Cottam Solar Project

Draft Statement of Common Ground

With the Environment Agency

Document reference: EX1/C8.3.8

Annex B - Proposed Cable Route and Watercourse Crossing Points

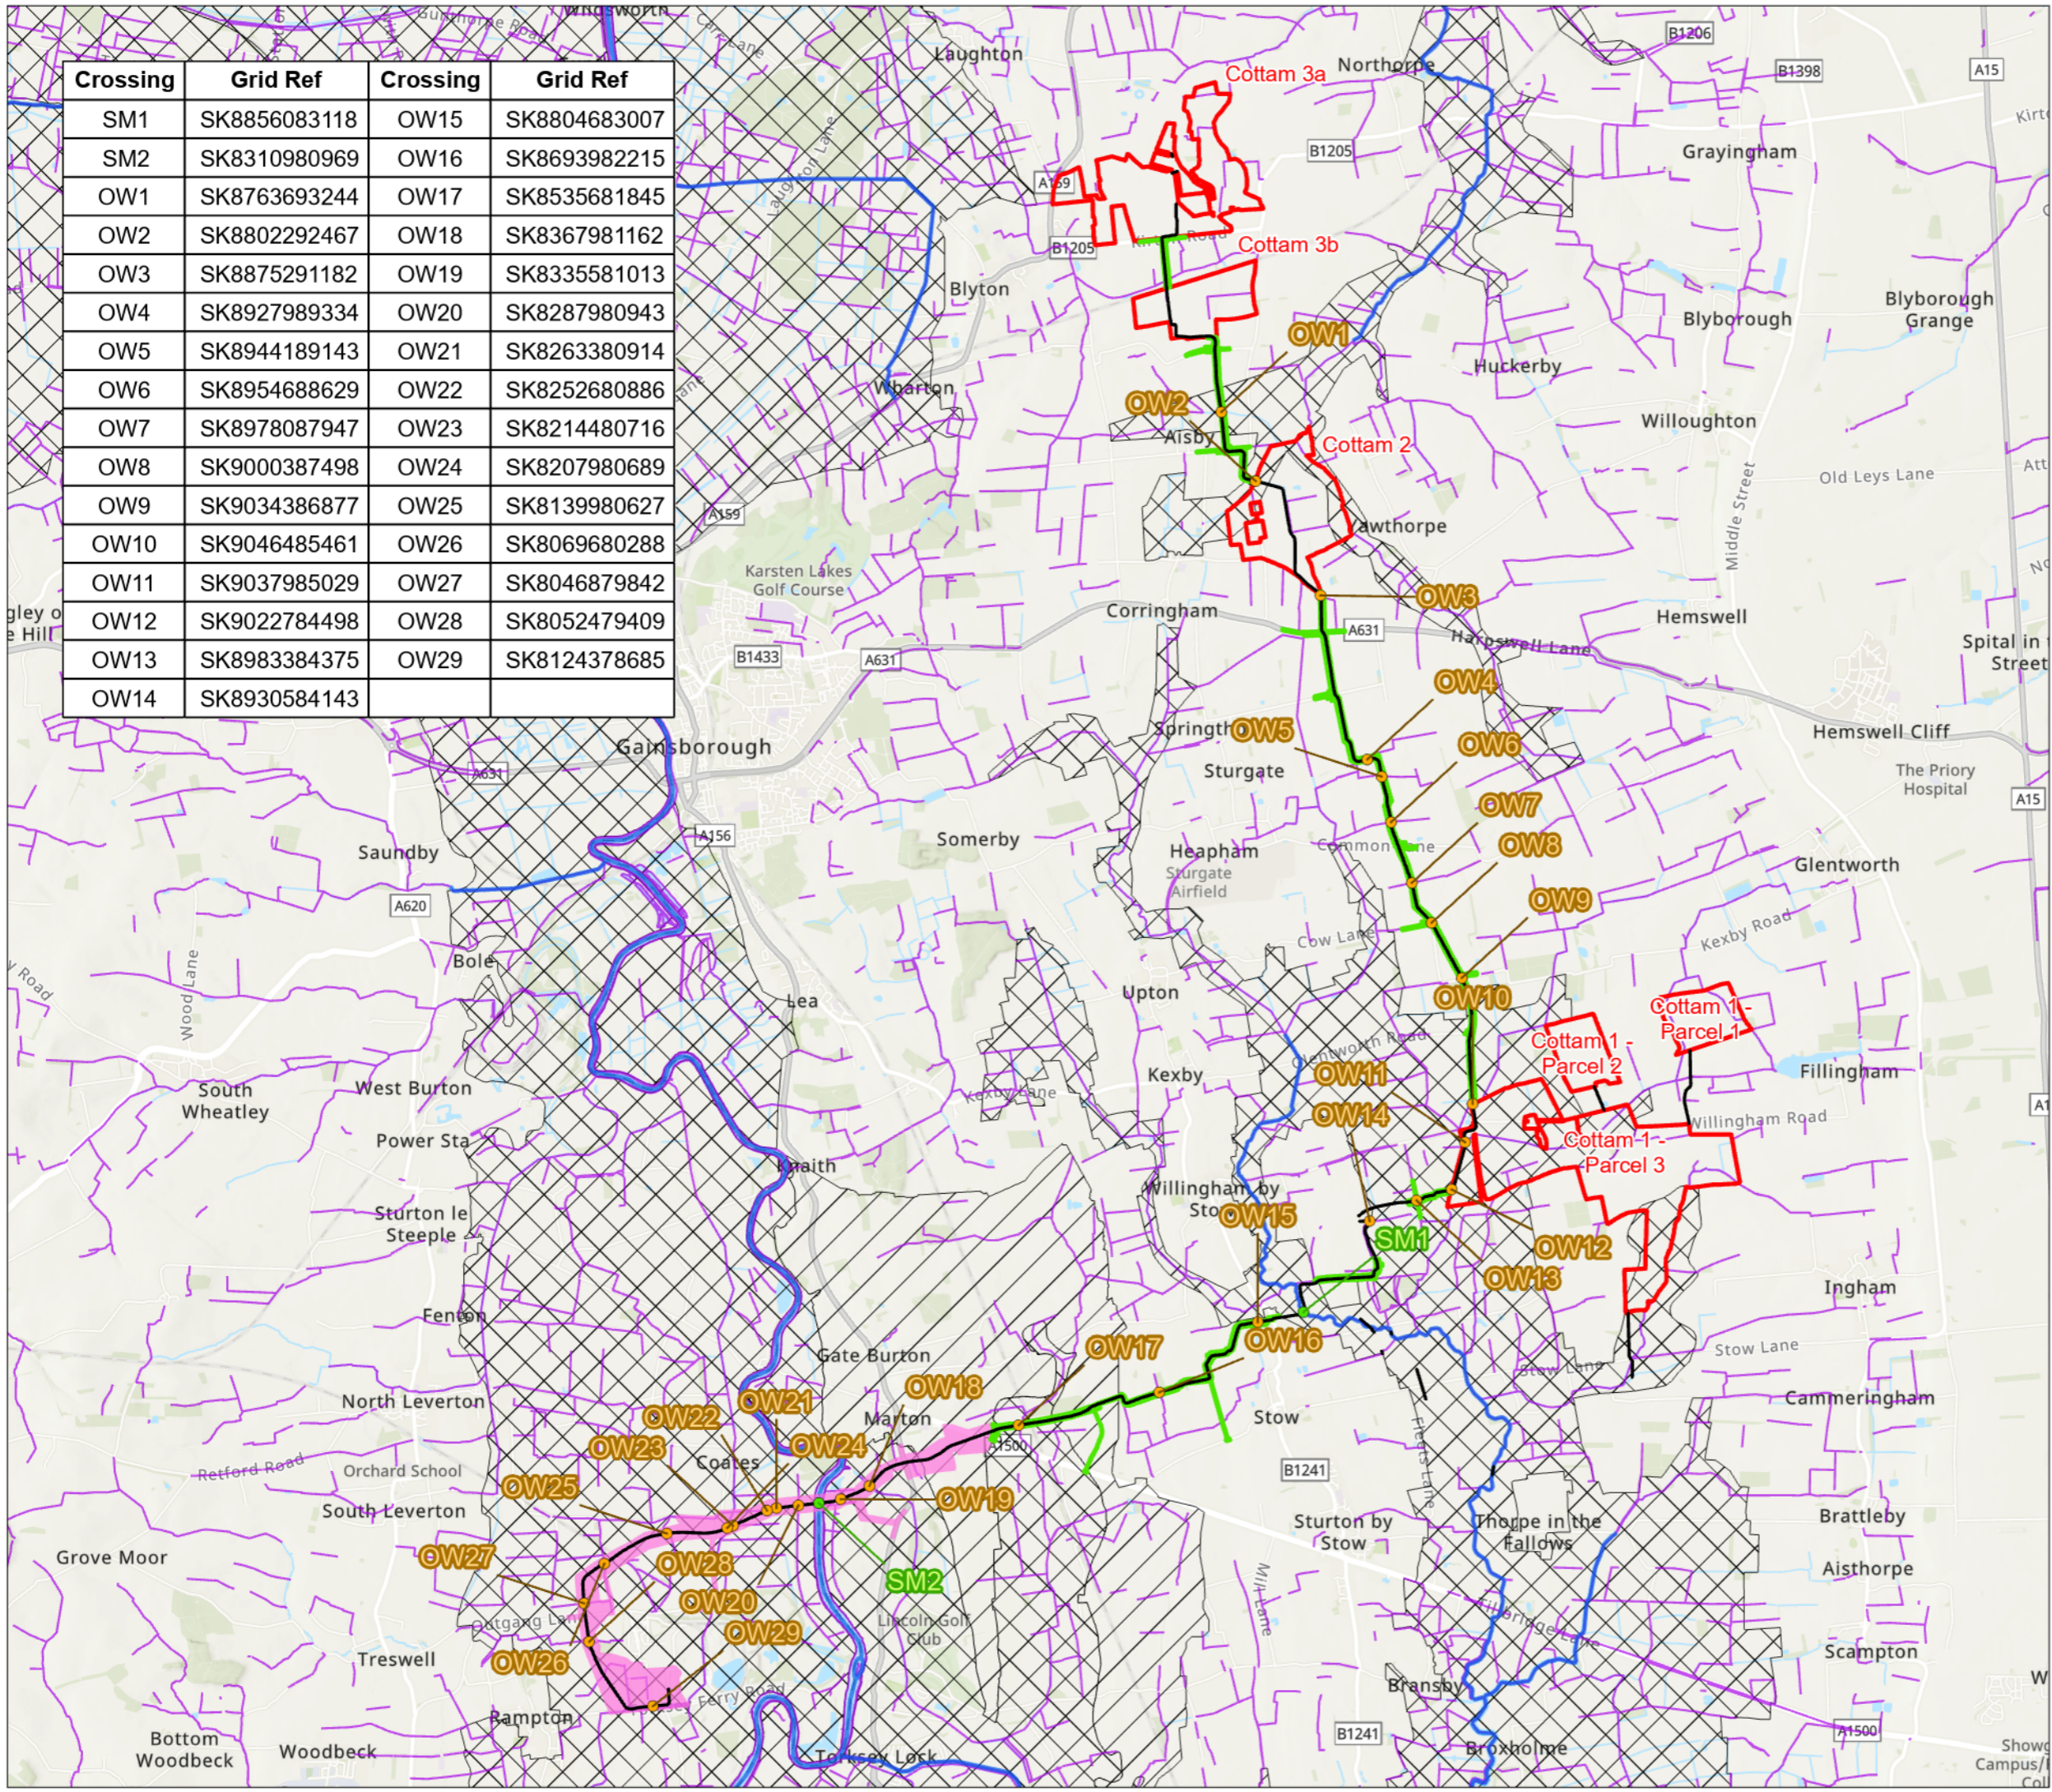
| <p>Hydrology HY-006</p> | <p>River Crossings</p> | <p>EA's Relevant Representation [RR-026]: "4.5. Where river crossings are proposed on the River Till and the River Trent these must be carried out using trenchless techniques. The use of open-cut techniques would be unsuitable at these locations, and we would object to any proposal of that nature. 4.6. The applicant is advised to follow the 'service crossing below the bed of a main river</p> | <p>The Applicant, as detailed within paragraph 4.5.51 of C6.2.4 ES Chapter 4 Scheme Description [APP-039], proposes to lay the cables across the River Till and Trent using trenchless techniques. The Applicant confirms that works will be carried out in accordance with the methodology within FRA3. The Applicant will formally apply for this exemption and confirms that paragraph</p> |

| | | not involving an open-cut technique (FRA3) methodology for the proposed river crossing. Carrying the works out in accordance with the methodology within FRA3 will ensure works are done to the required standard in terms of flood risk.” | 4.5.52 of C6.2.4 ES Chapter 4_Scheme Description [EN010133/EX1/C6.2.4_A] will be amended to confirm that launching, and landing pits should be located at least 16m away from tidal rivers (e.g., the Trent) as per exemption FRA3. |
